## Submission Form

Epping to Thornleigh Third Track Proposal. Application number SSI 5132.

Figure S.6 Cross-section and elevation - New Cheltenham Station concourse building (see also S.5 for artist's impression)

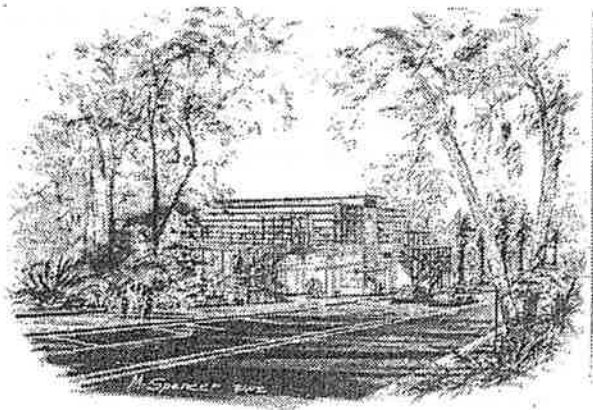
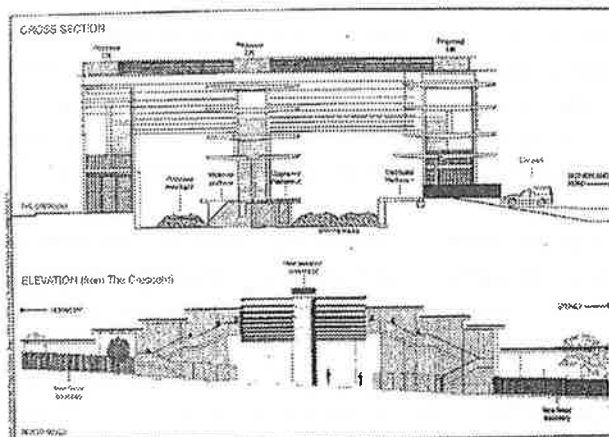
- The proposed redevelopment of Cheltenham Station shows no regard for the HCA. The visual impact of the proposed 13m high glass and steel concourse is totally unacceptable in this HCA.
